To	LBH Highways	Date: 28th June 2022
cc	Billy Palmer – Bidwells, Tim Martin - LBH, Mark Clarke - CDC	Ref: 3249/007/007

1. Robert West were appointed by the London Borough of Hillingdon (LBH) in February 2022 to provide transport planning advice in relation to the expansion of Meadow High School at Harefield Academy.

4. This addendum has been provided to address comments and feedback from the LBH Highways Officer dated the 8th June 2022 and address any potential impacts resulting from the proposed amendments. In summary, the proposed amendments would have no material impact on the results and recommendations of the assessment as submitted with the original application.

## Appendix B – 20mph Zone Plan

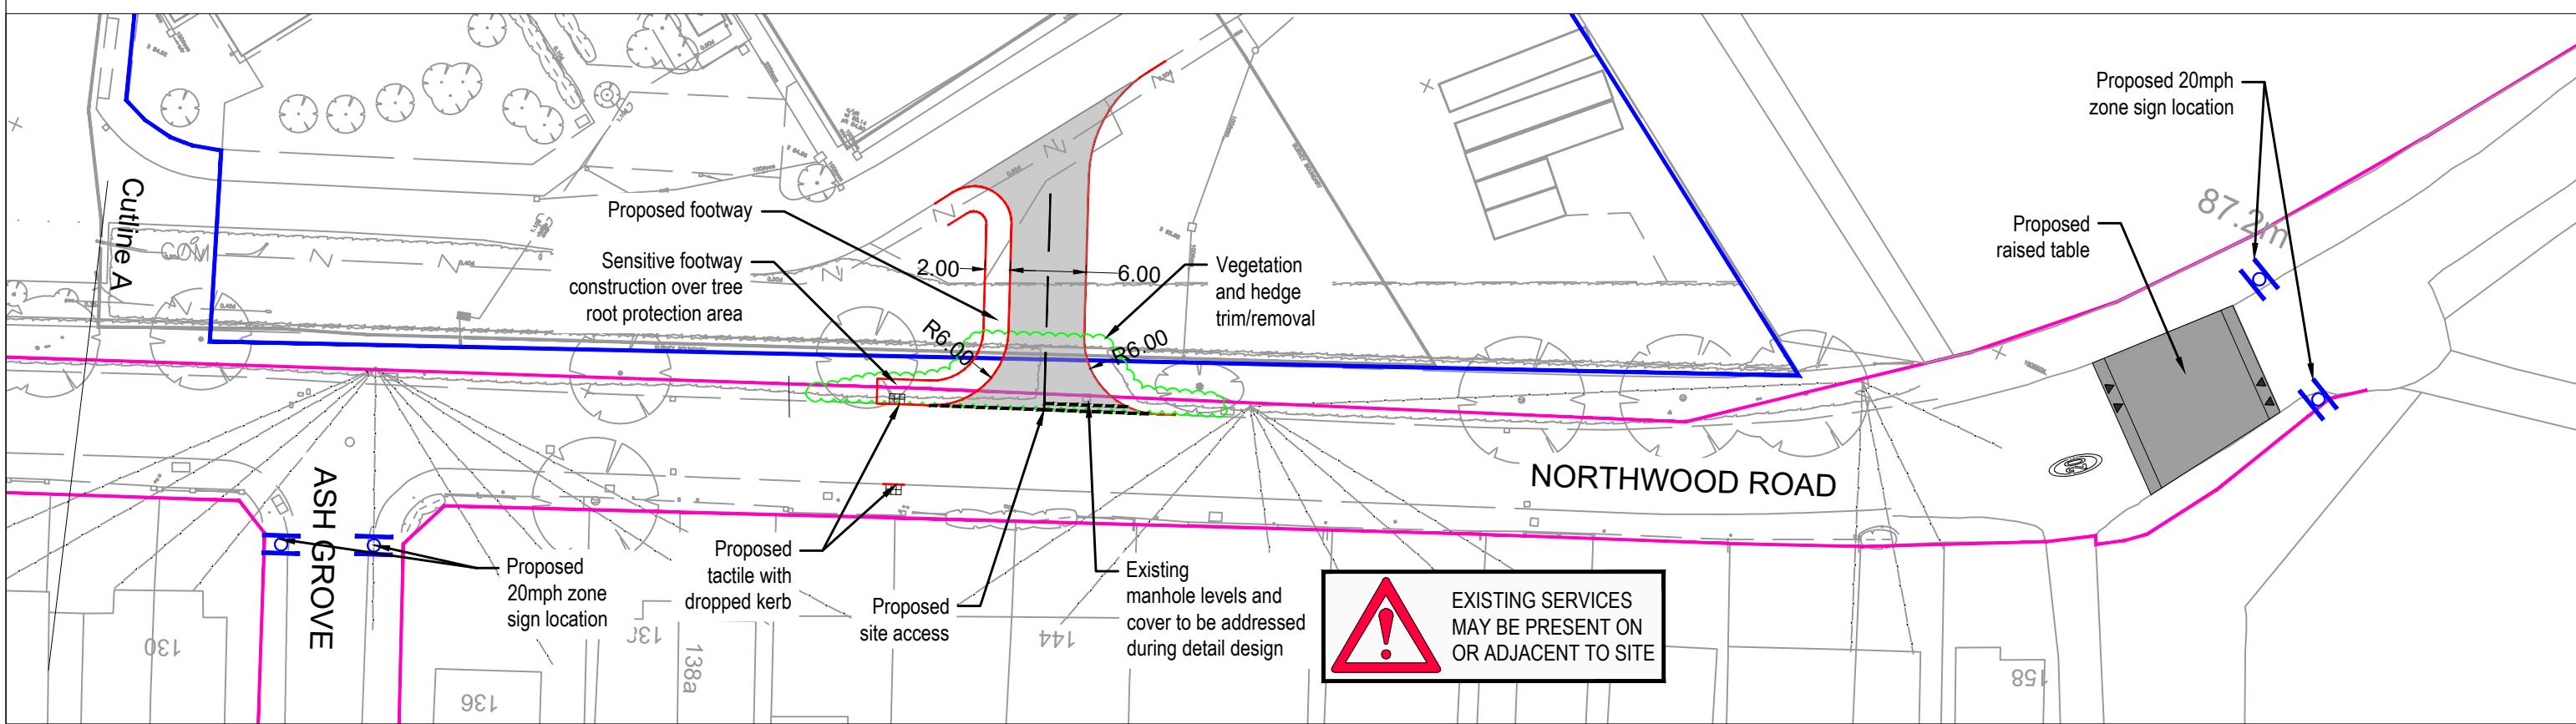
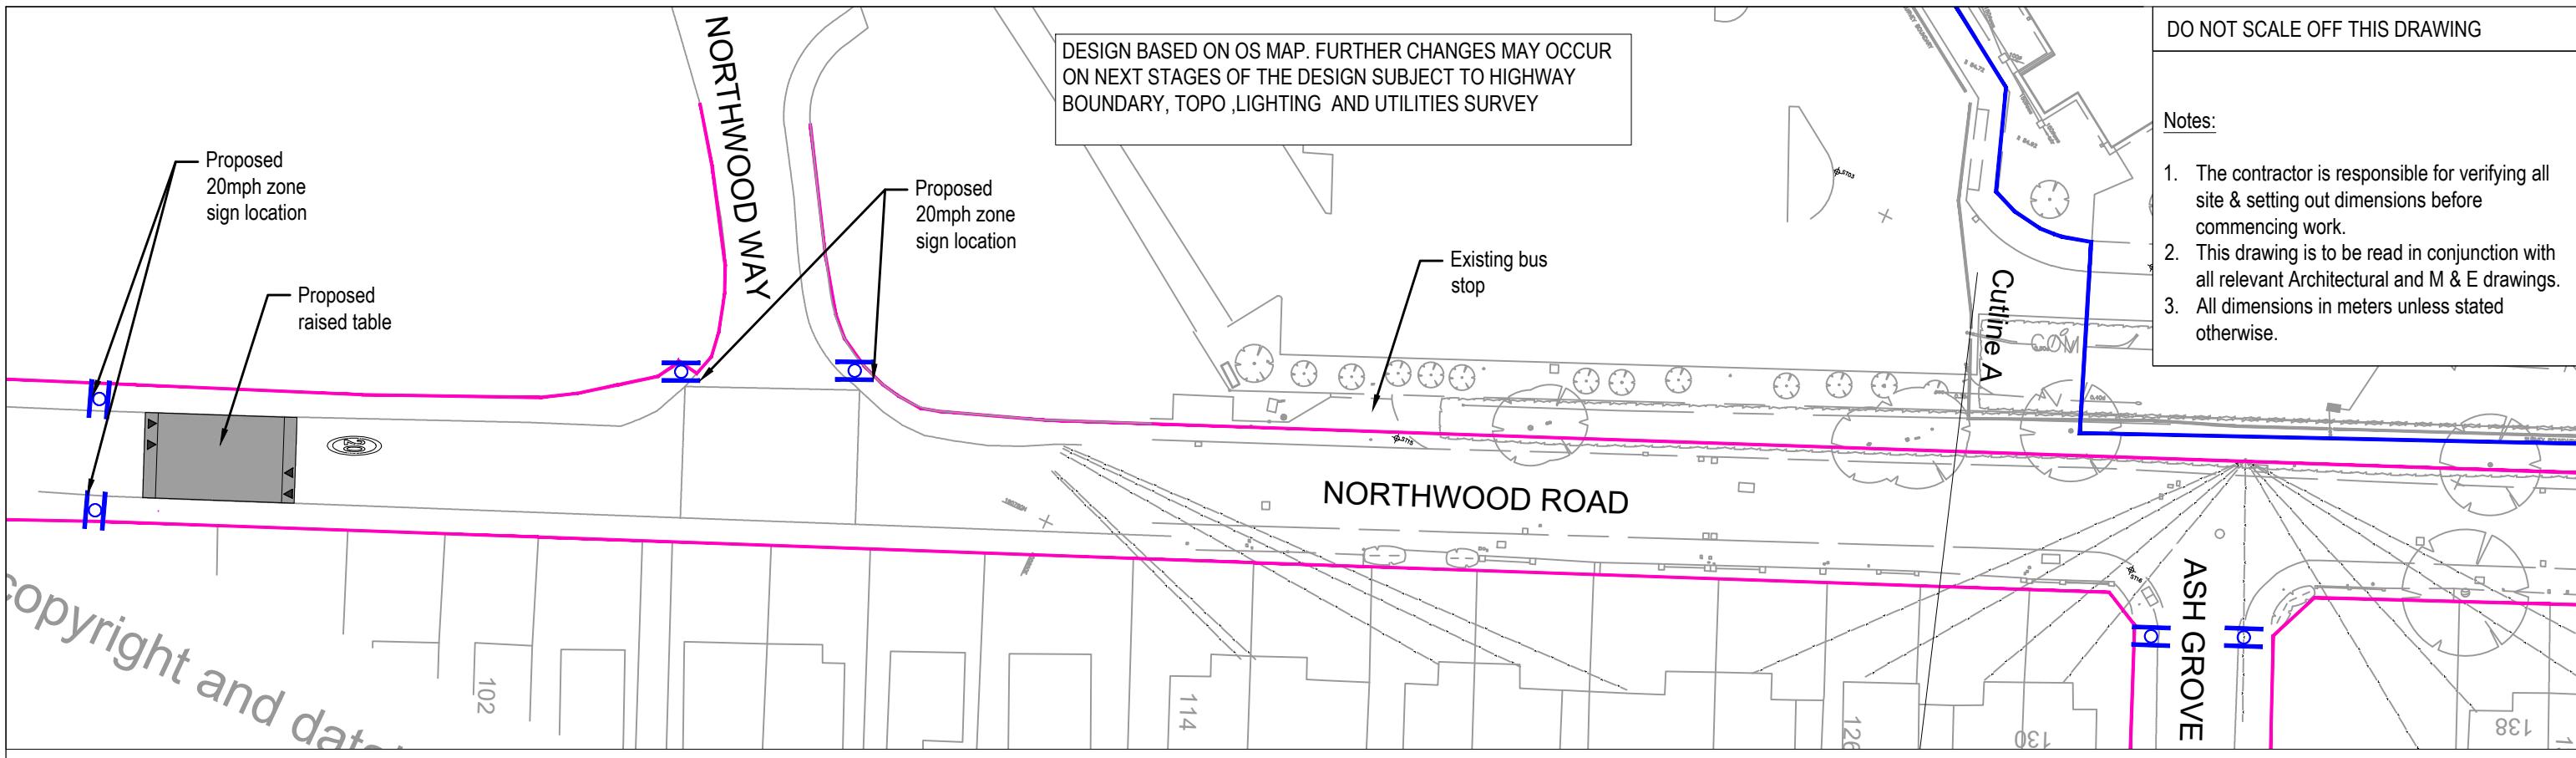
11. Changes to the proposed development scheme include the removal of the proposed 20mph zone on Northwood Road within the vicinity of the site as advised by the LBH Highways Officer.

14. It is noted that with the removal of the 20mph zone from the development proposals, high vehicle speeds and pedestrian safety concerns on Northwood Way are no longer addressed. To mitigate pedestrian safety concerns, pedestrian access is now proposed from the Harefield Academy access on Northwood Way moving proposed pedestrian movements from Northwood Road. The proposed site access on Northwood Road will be dedicated for vehicles and cyclists only.

15. This approach was suggested by the LBH Highways Officer and is considered to be acceptable given the low volumes of total daily vehicle movements at the proposed site access (118 vehicle movements).

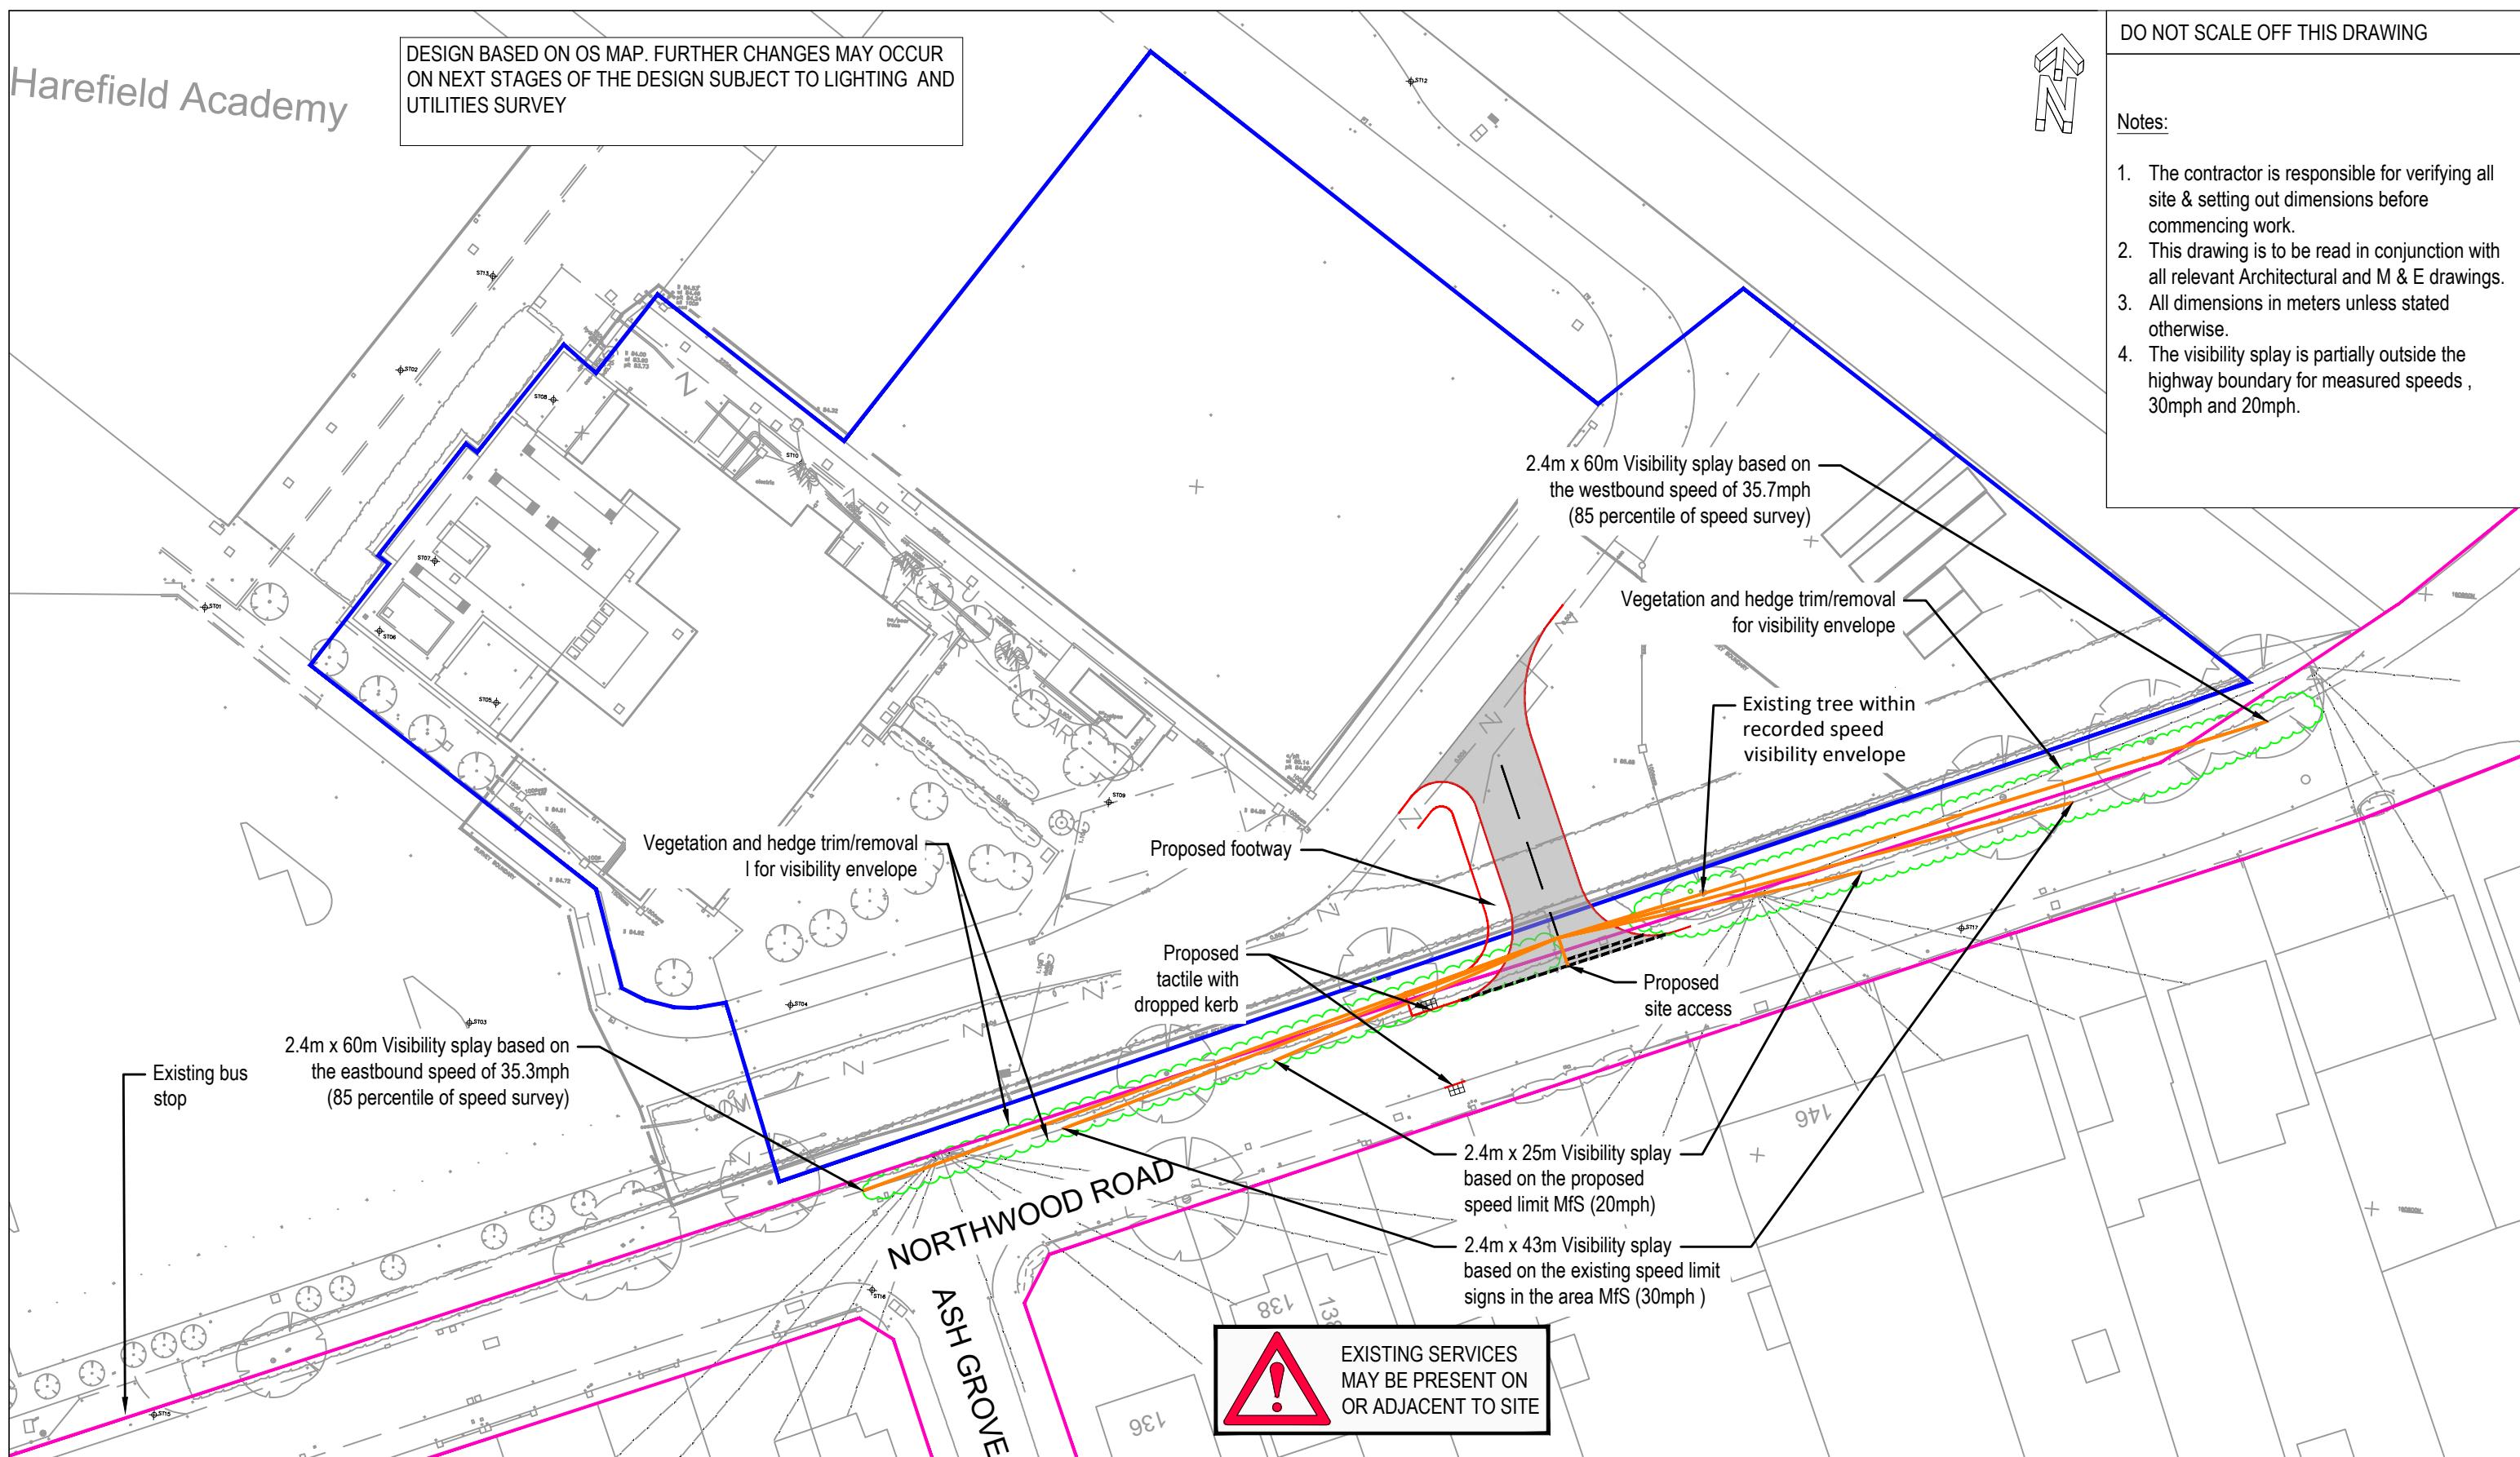
7. The LBH Highways team have requested the following items to be conditioned and the applicant accepts these conditions:
 - i. Further details regarding Electric Vehicle Charging Points to be provided and secured by planning condition.

9. Changes to the proposed development scheme include the removal of the footway for pedestrians at the site access and the pedestrian crossing on Northwood Road at the site access. The proposed site access is proposed to be dedicated vehicular access. Cyclists can also use this access. This approach was recommended by LBH Highways Officer. The updated Site Access General Arrangement drawing and vehicle tracking is attached at Appendix A. No geometric changes to the site access are required subsequent to the removal of the footway at the site access.
